From: Sue Howell
Sent: 05 December 2018 16:11
To: Planning.Responses
Cc: Anita Gardner
Subject: RE: Planning Consultation on LU/276/18/DOC

APPLICATION LU/276/18/DOC
NO:

Registered: 03-OCT-18
Site Address: 1 Tulley Cottages Toddington Lane
Littlehampton BN17 7PW

Description of Works: Approval of details reserved by condition imposed under LU/251/15/PL relating to condition 4-landscape scheme

PROJECT NAME
Planting Plan

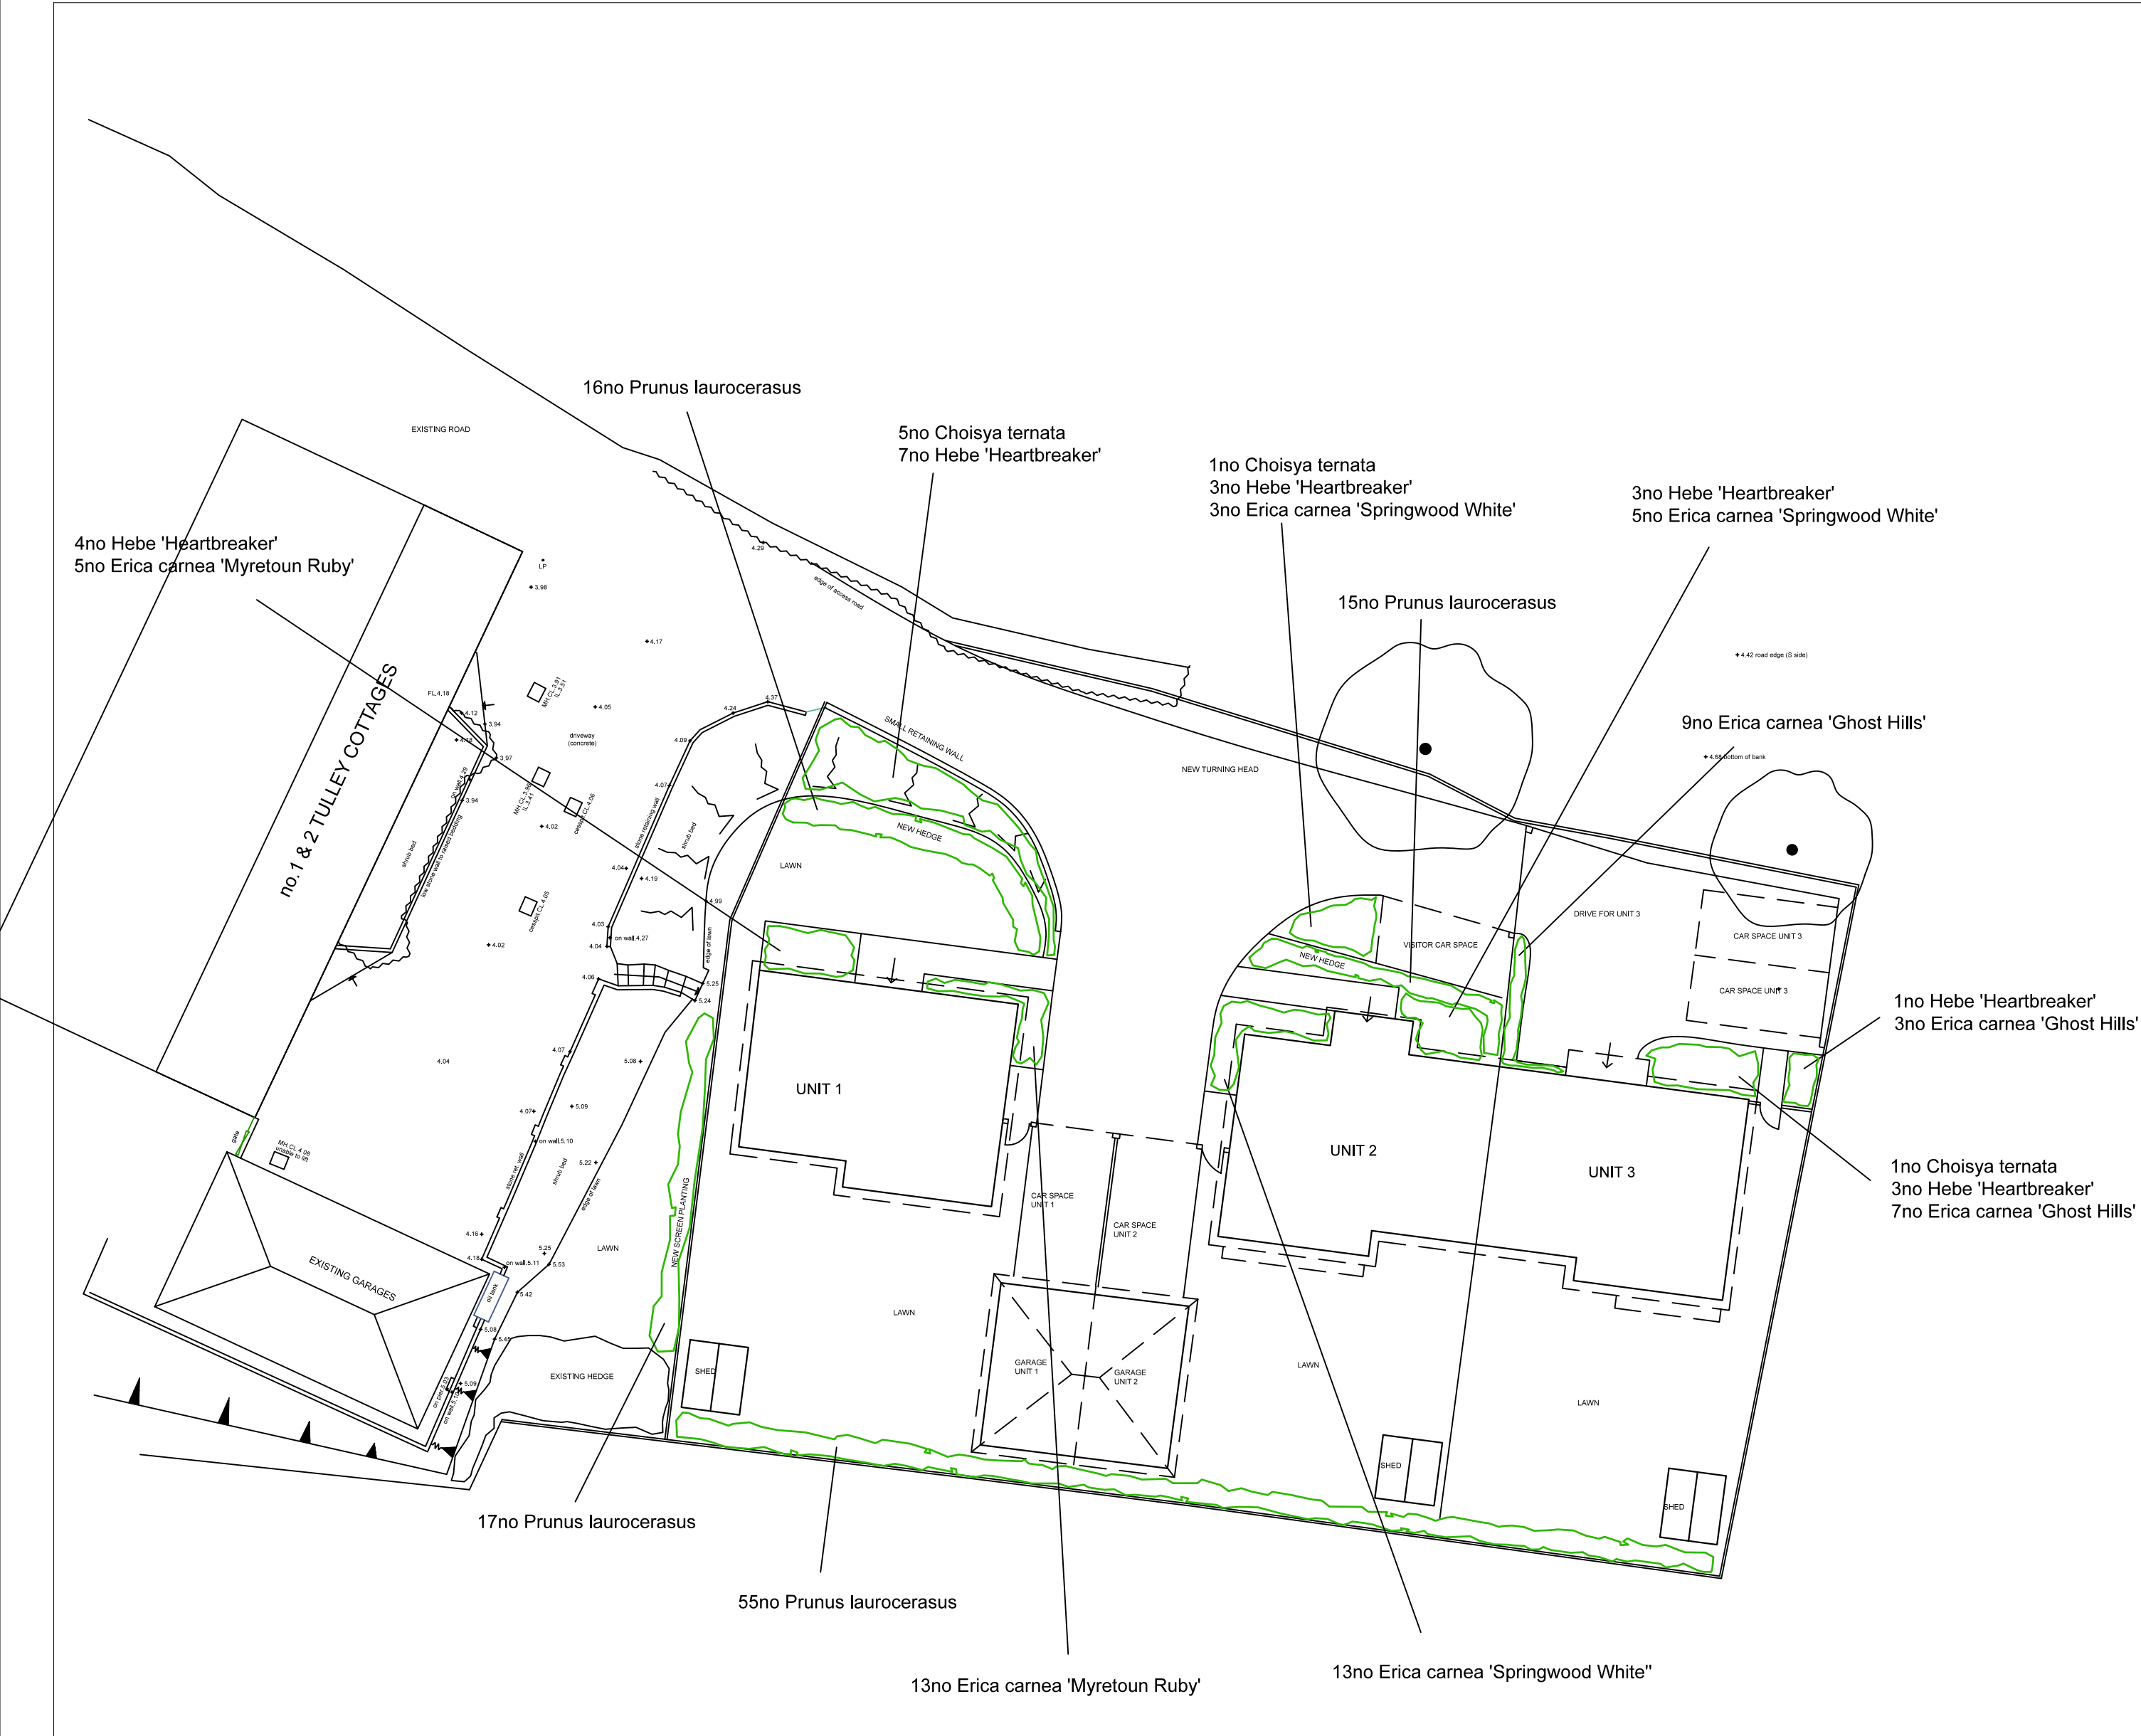
Further to submission of planting plan 28.09.2018, I can confirm that the information supplied does propose a well thought out and comprehensive scheme which is fitting for location in sufficient plan detail and therefore we would recommend the discharge of Condition 4 Landscaping scheme reserved under planning approval LU/251/15/PL on this application LU/276/18/DOC.
